Subject: FW: WA/21/21/DOC - Wandleys Farm Condition 3 Materials

1. **Eaves Detail** – please find attached drawing 944 BR07A which includes the eaves detail for the new affordable housing (bungalows). The same eaves detail will be used for the house.

Subject: WA/21/21/DOC - Wandleys Farm Condition 3 Materials

A	MINOR AMENDMENTS	09.03.2
REV	DESCRIPTION	DATE
PROJECT LOW COST HOUSING UNITS WANDLEYS FARM WANDLEYS LANE FONTWELL		
CLIENT MR & MRS K LILLYWHITE		
DRAWING TITLE CONSTRUCTION DETAILS SHEET 1 OF 2		
SCALE	DRAWN BY	DATE
1:5 @ A1	TP	JAN 21
DWG NO	944/BRO7	REV. A

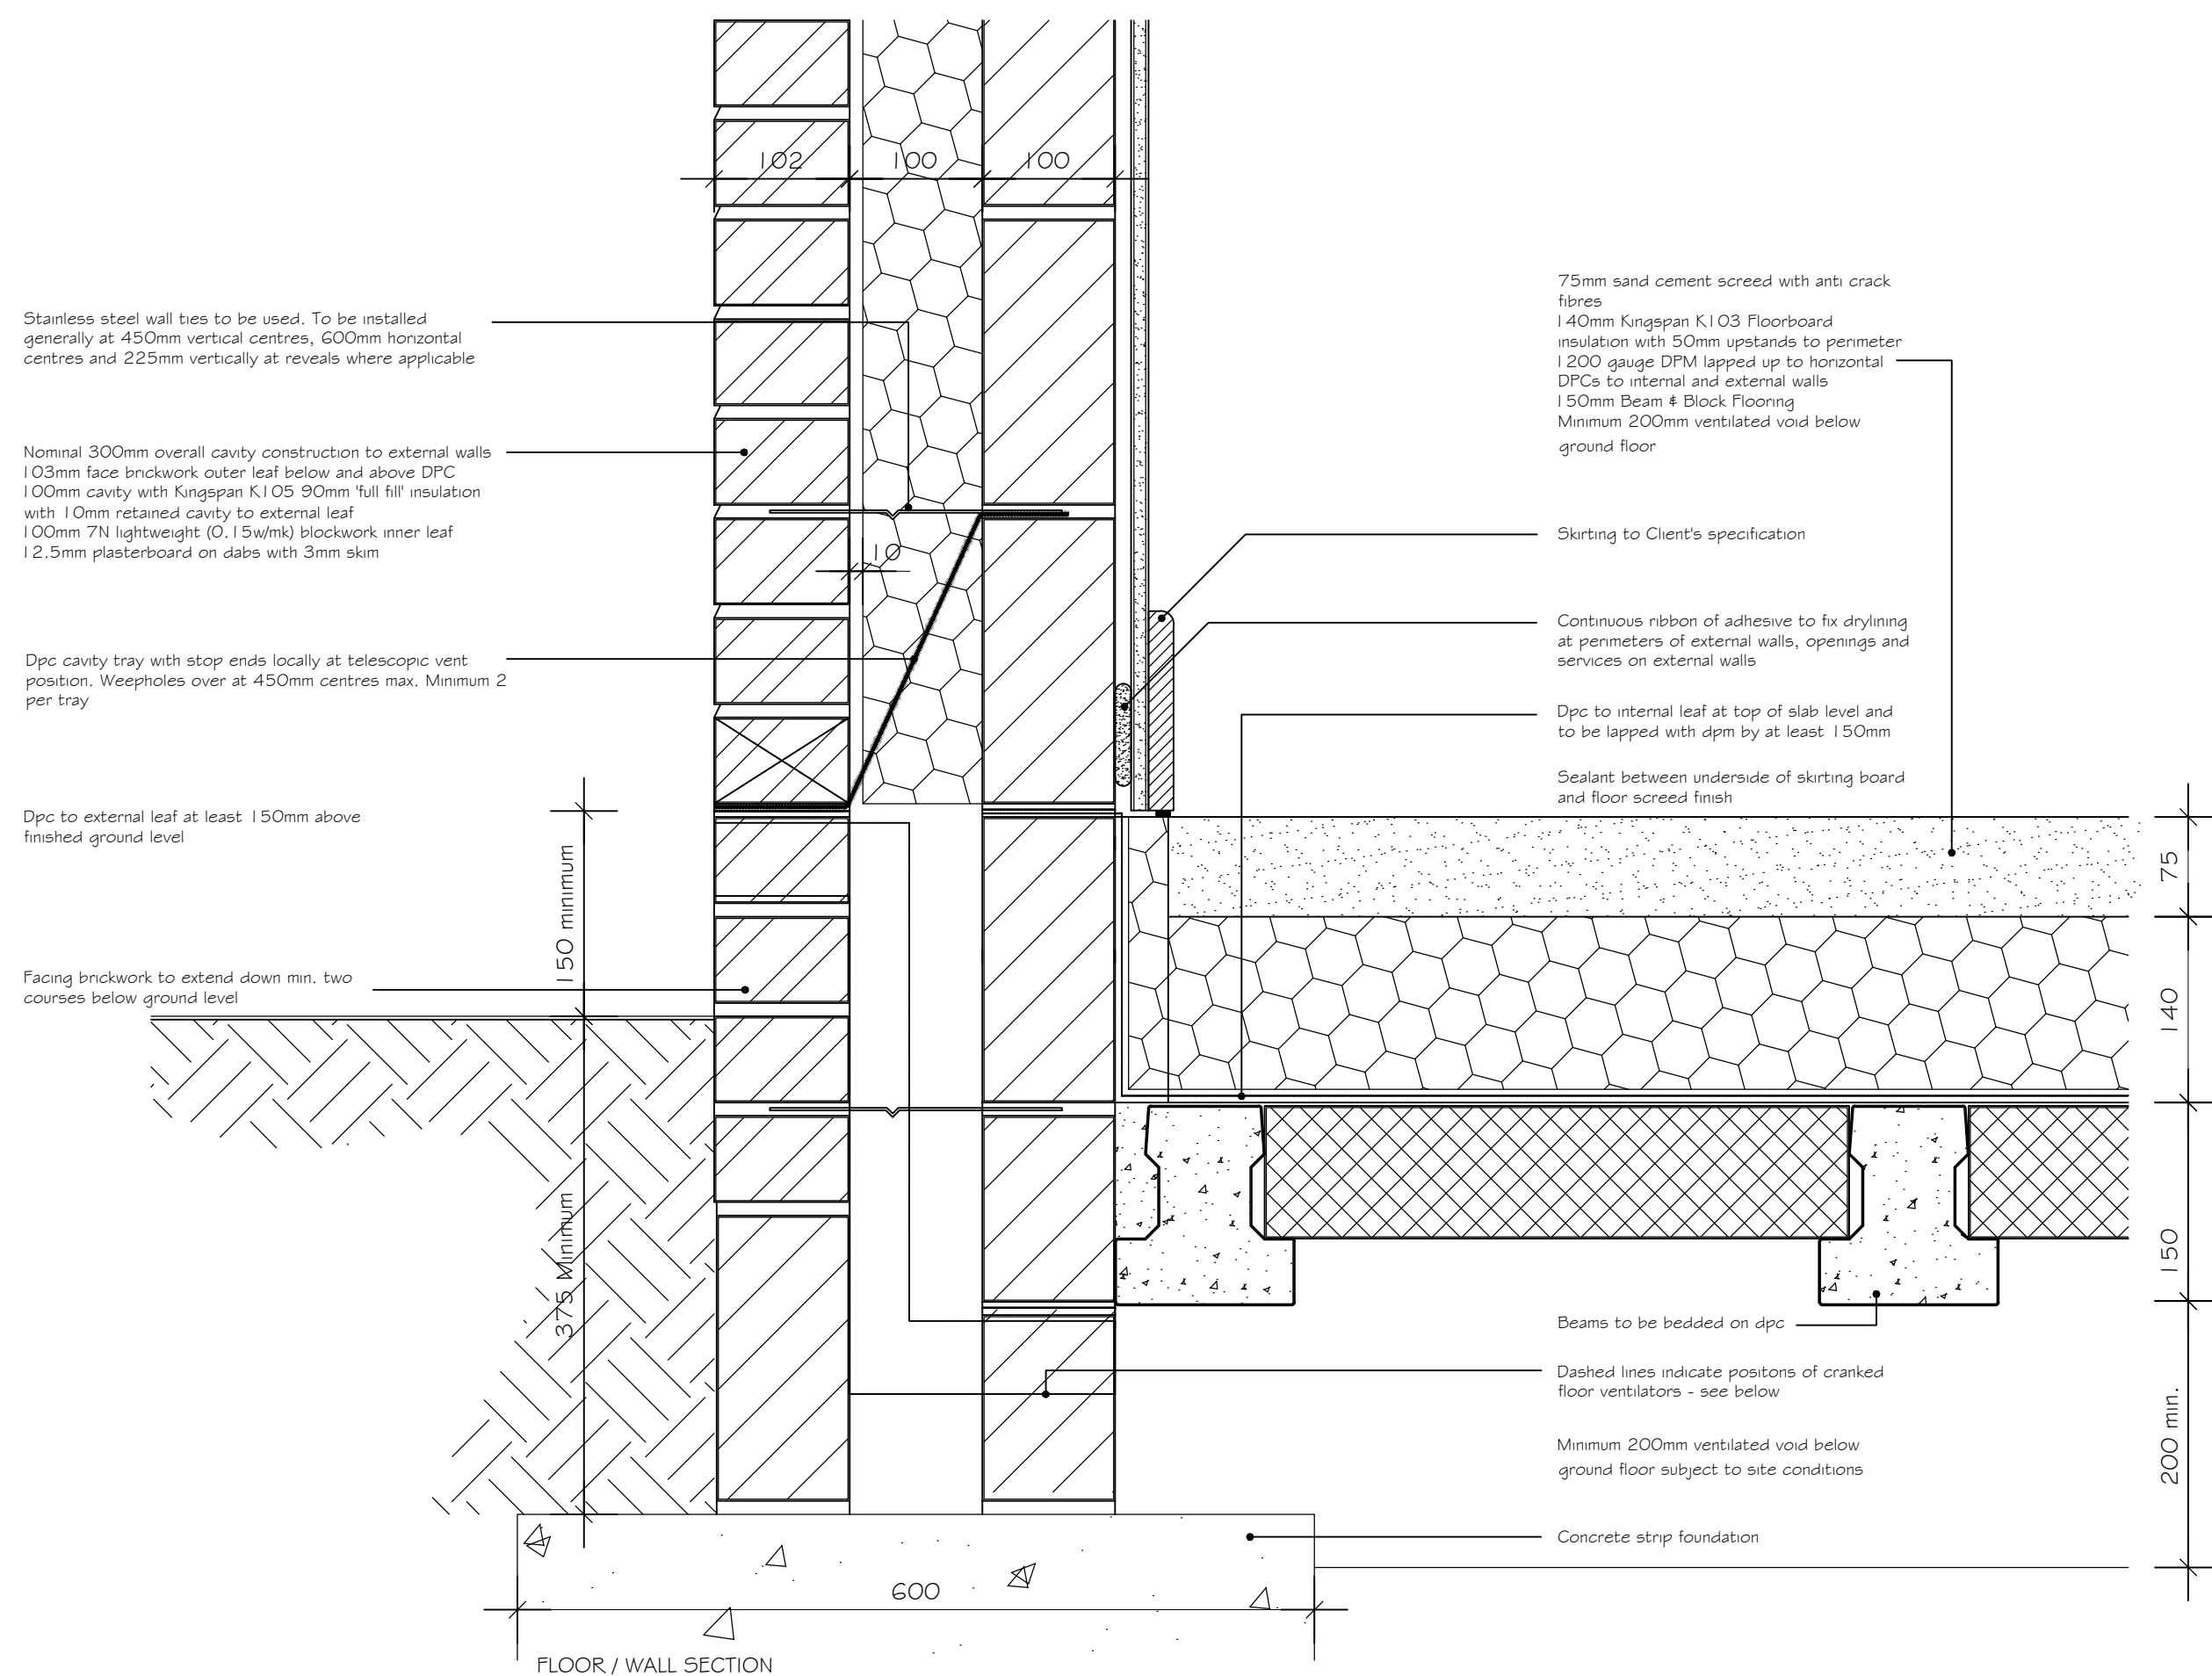
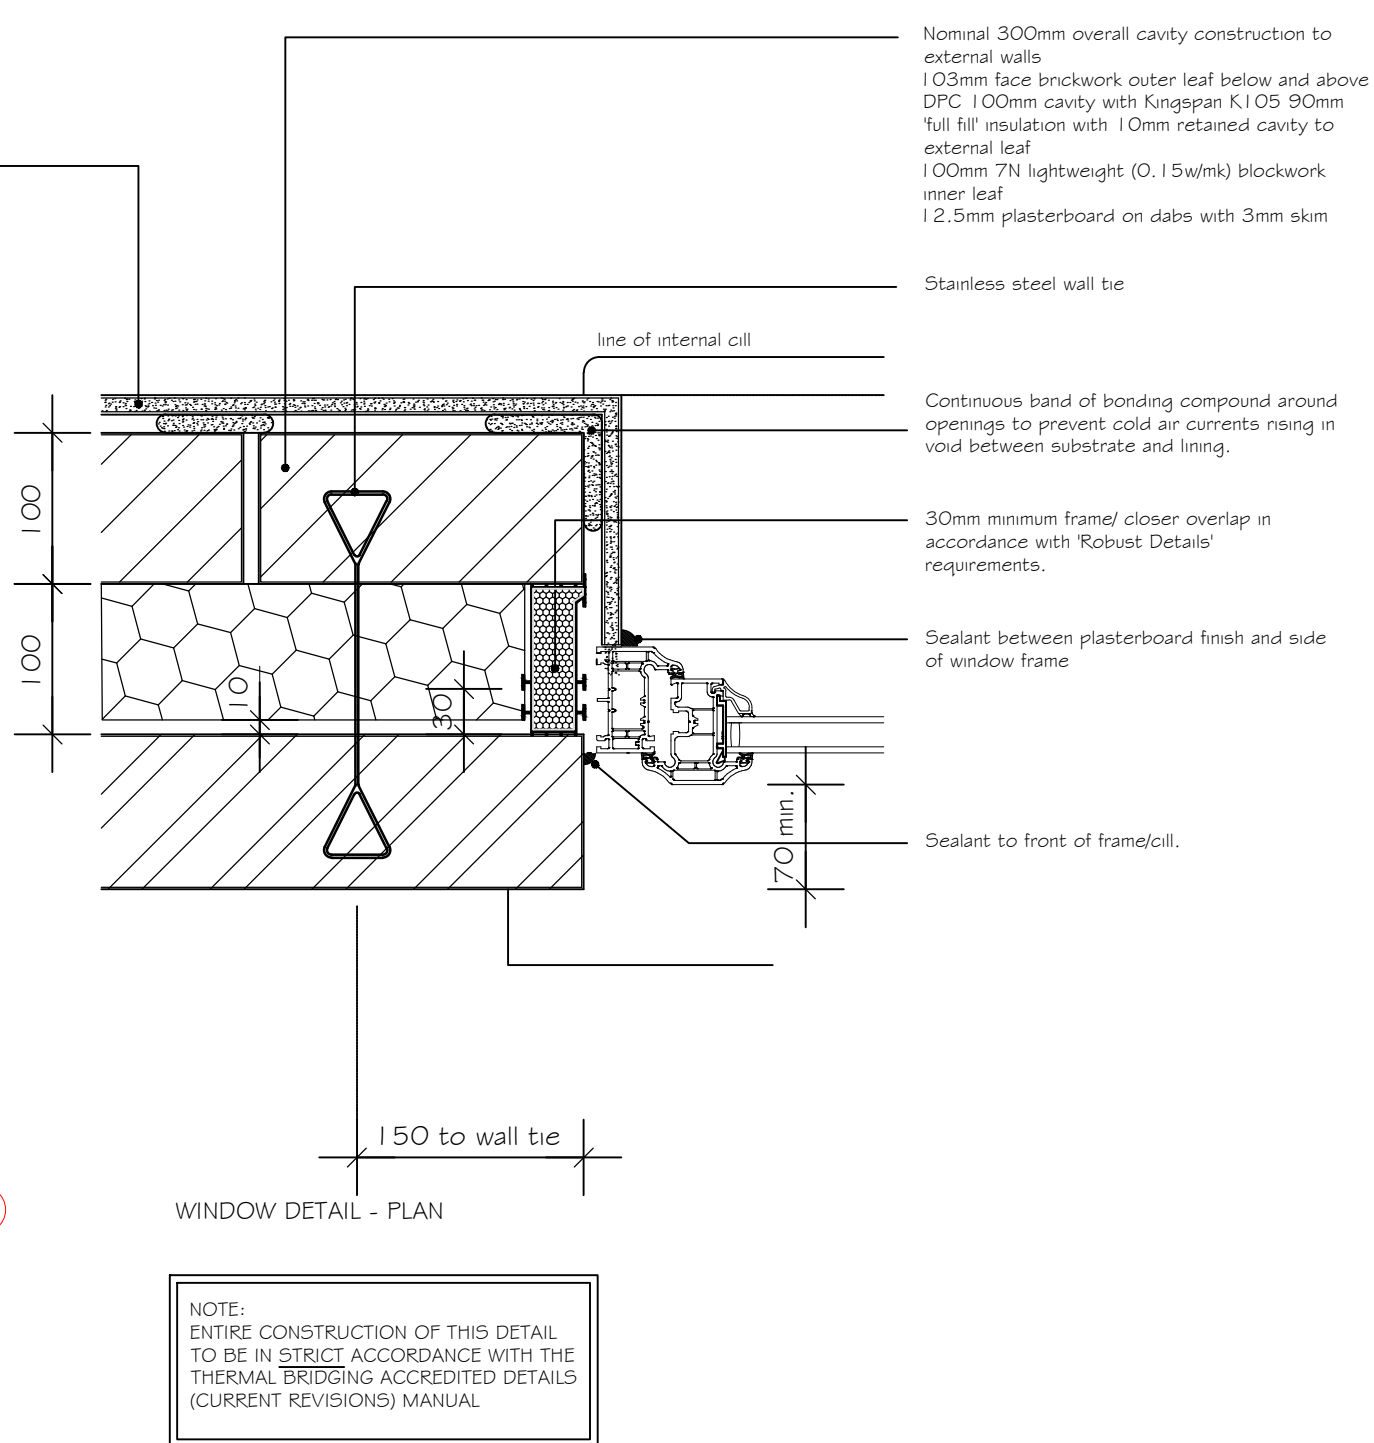
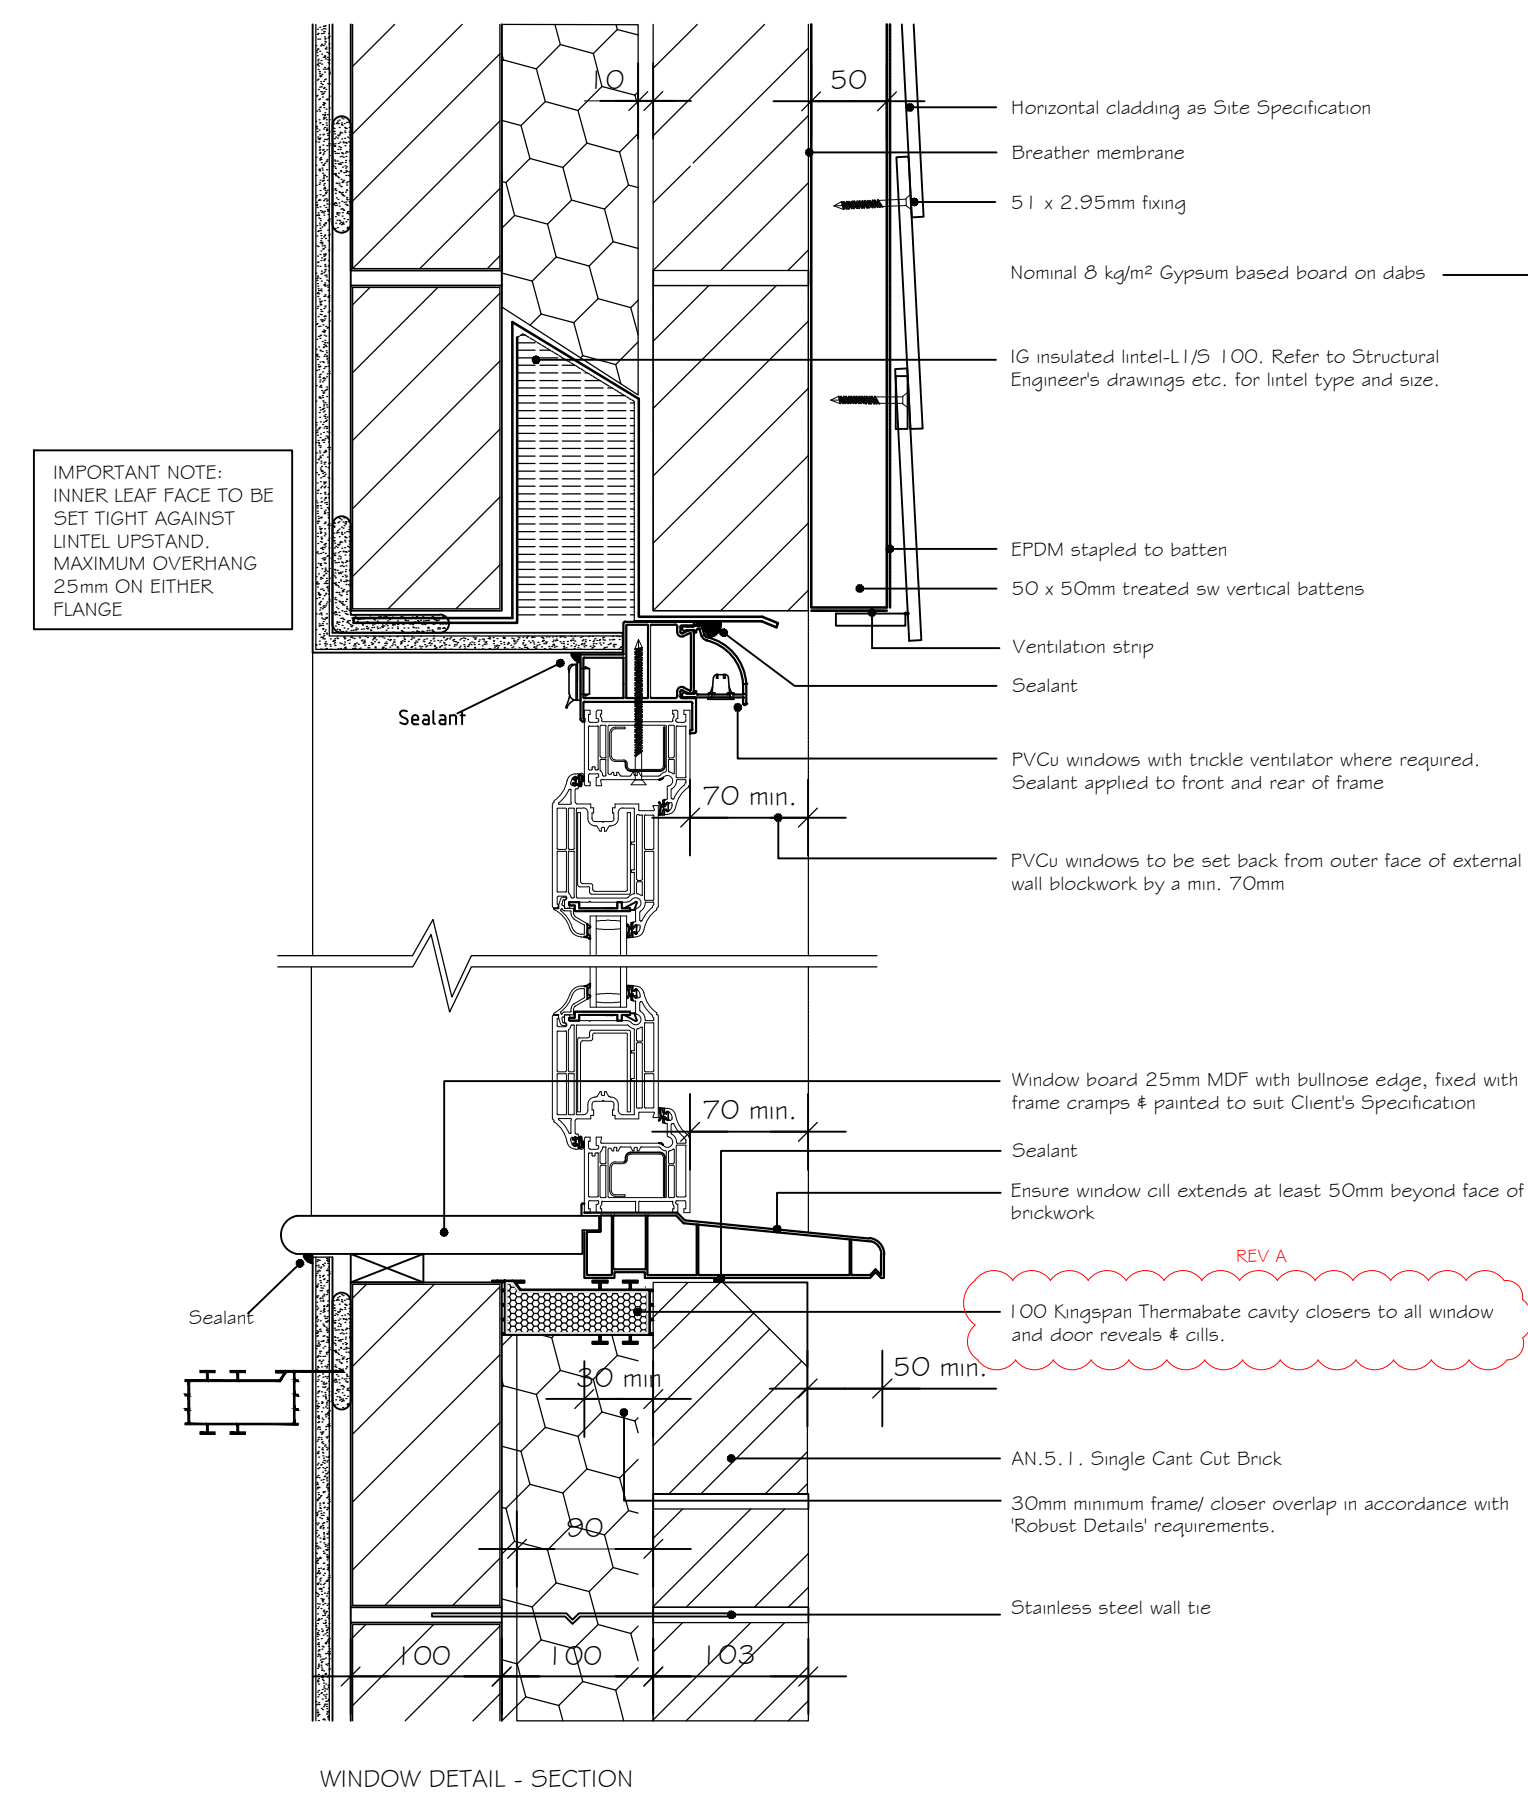
The above application does not contain any eaves detail as required by the condition. If these are not provided within the next 7 days the application will be determined as submitted.
